DOOLEY'S LIDCOMBE CATHOLIC CLUB - SSD 7603

COMMENTS FROM CUMBERLAND COUNCIL

Thank you for the opportunity to comment on the Concept Proposal for Tourist Related Purposes and Detailed Proposal for early works at Dooleys Lidcombe Catholic Club, Lidcombe, SSD 7603.

PARKING SCHEDULE
Disabled Carpark Bay
14
Standard Carpark Bay
596
Grand total: 610

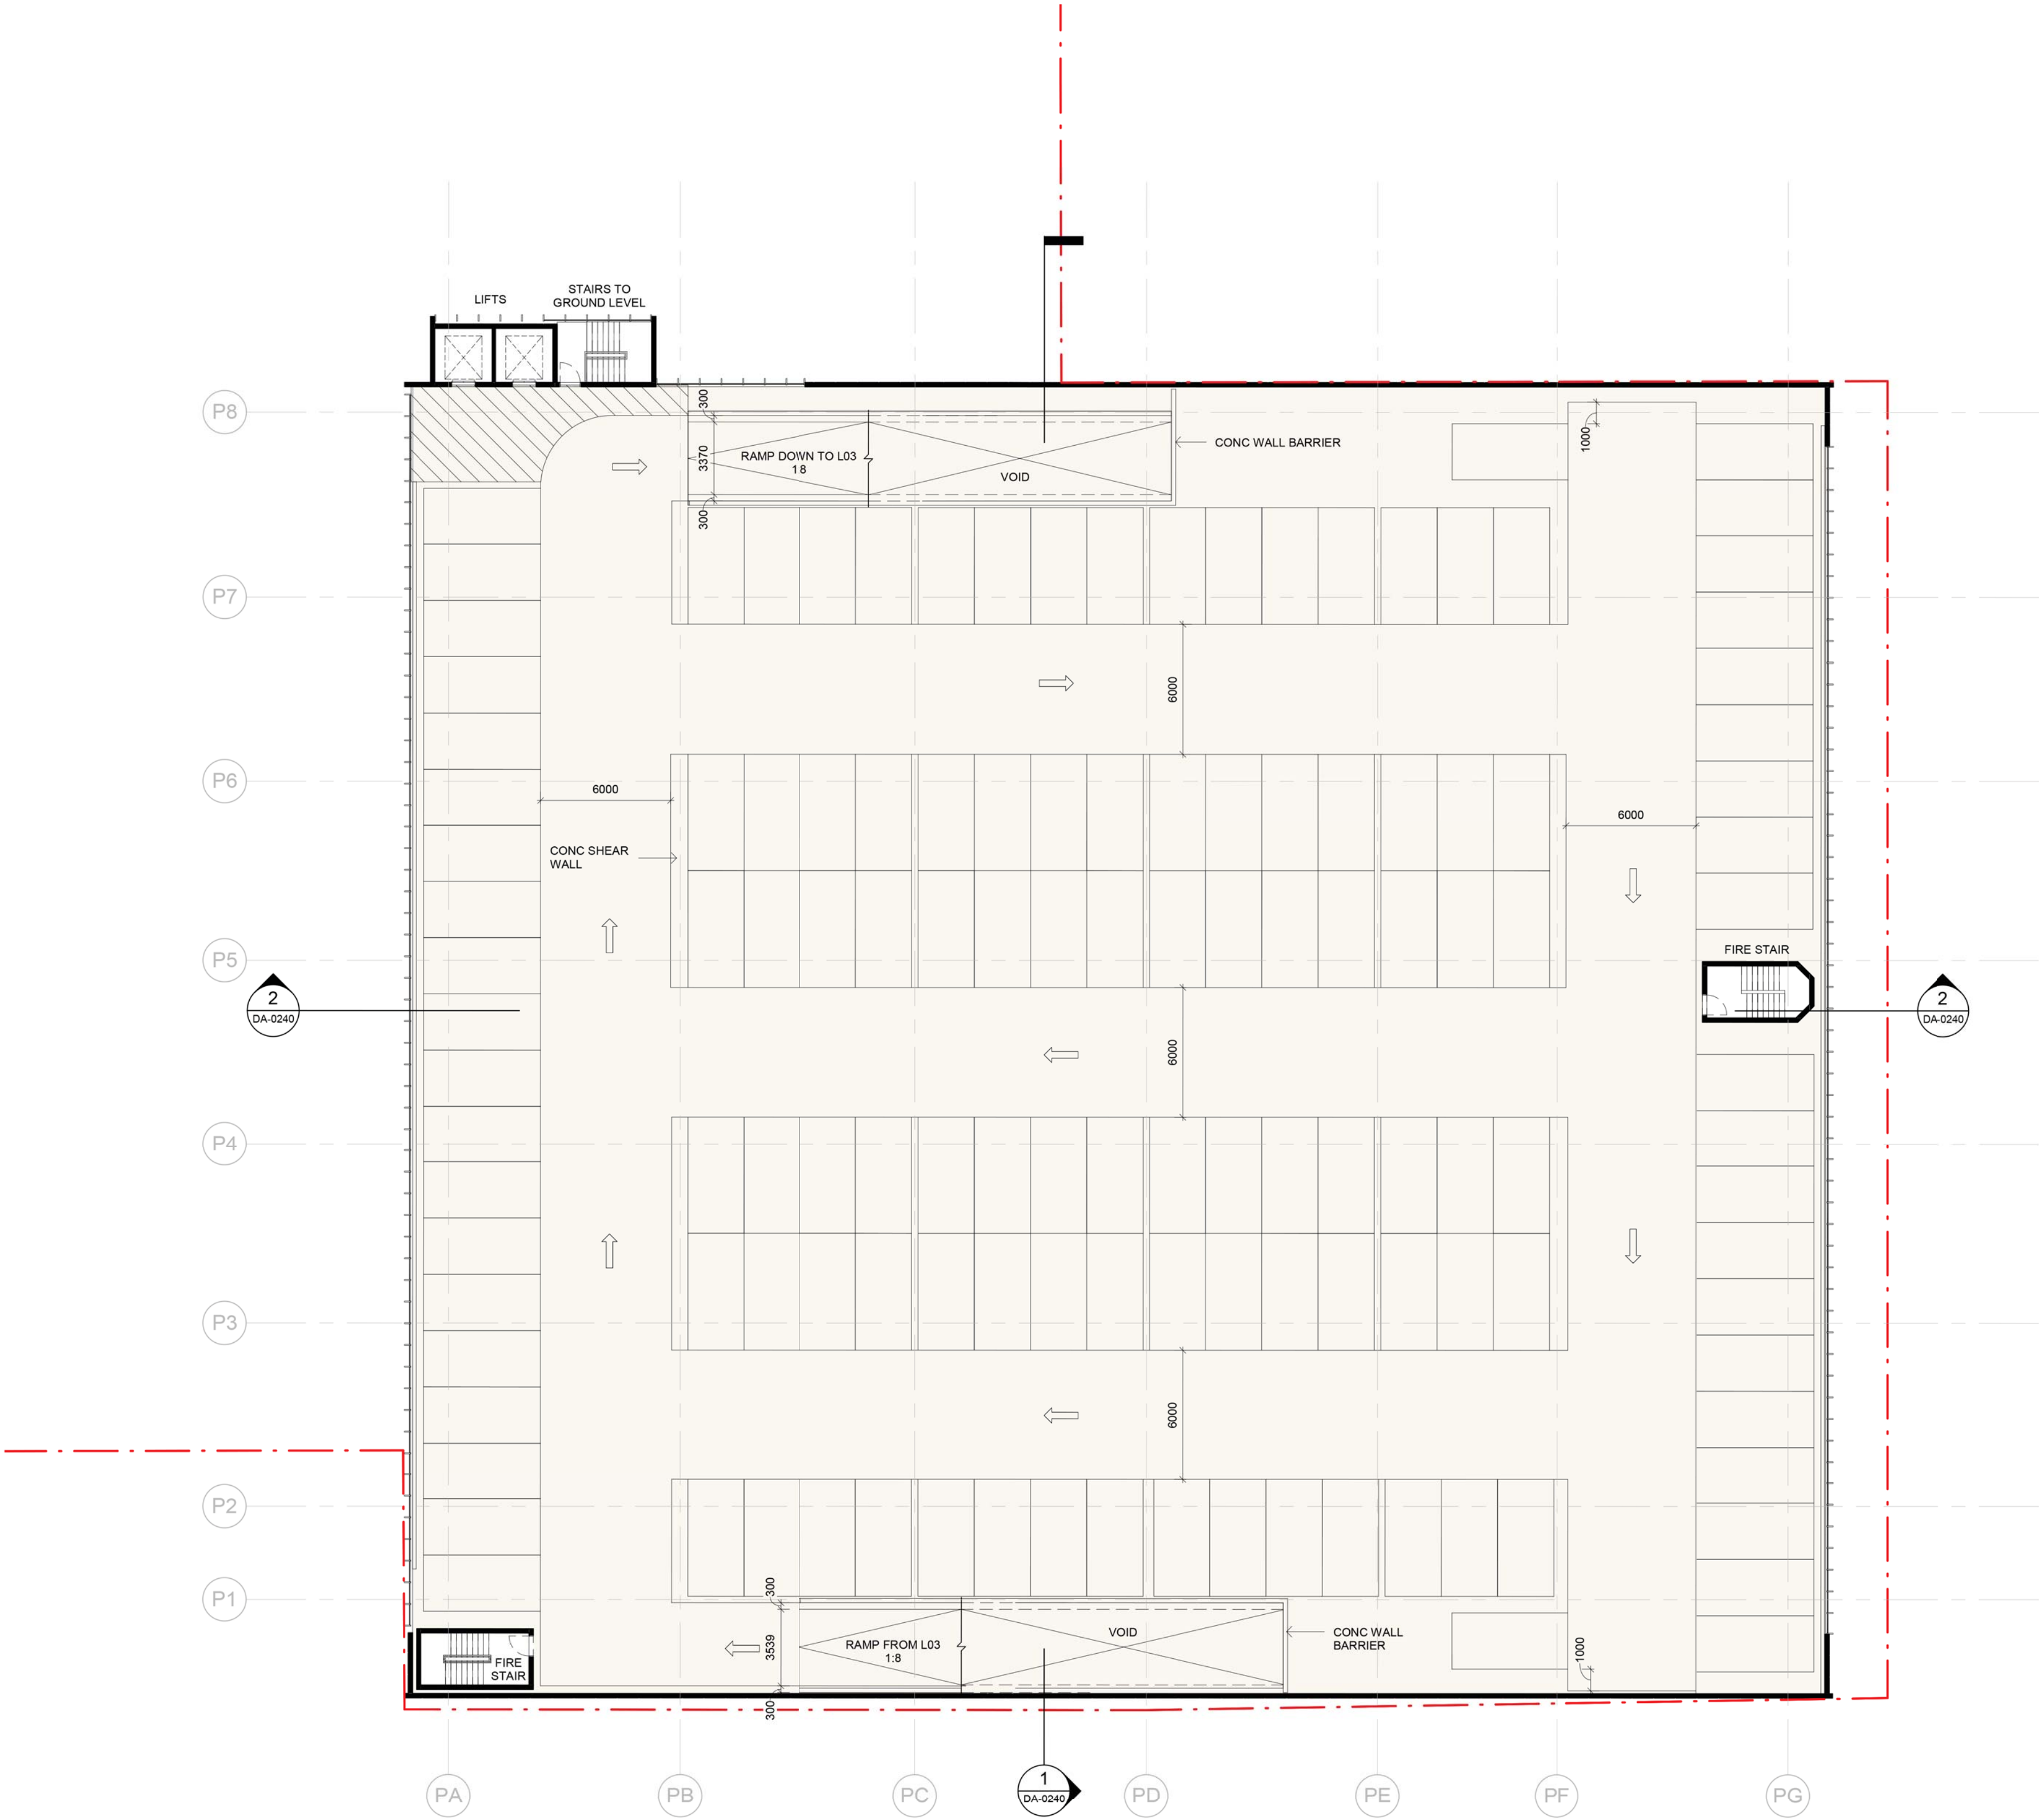
The requirements of *Built Form, Urban Design and Public Domain – Stage 1* of the SEARS do not appear to have been addressed in relation to the multi-storey car park. Discussion of alternatives to the above ground car park or provision for adapting the building for future uses, and activating the ground floor, could not be found in the documentation provided.

Council strongly recommends that there be adequate basement parking to address the requirements of the entire concept plan, without relying on above ground car parking. Should the Department nevertheless accept the concept of a permanent above ground car park in the future commercial area of the town centre, it is requested that:

- a. The structure be sleeved in active uses along Board St to support a vibrant active Lidcombe centre, eg small professional offices
- b. That some of the parking within the structure be provided at basement level

- c. That the building be substantially setback from Ann St, with deep soil landscaping including trees in the frontage to the site (eg 4-6m)
- d. That there be a substantial landscaped setback to the isolated sites:
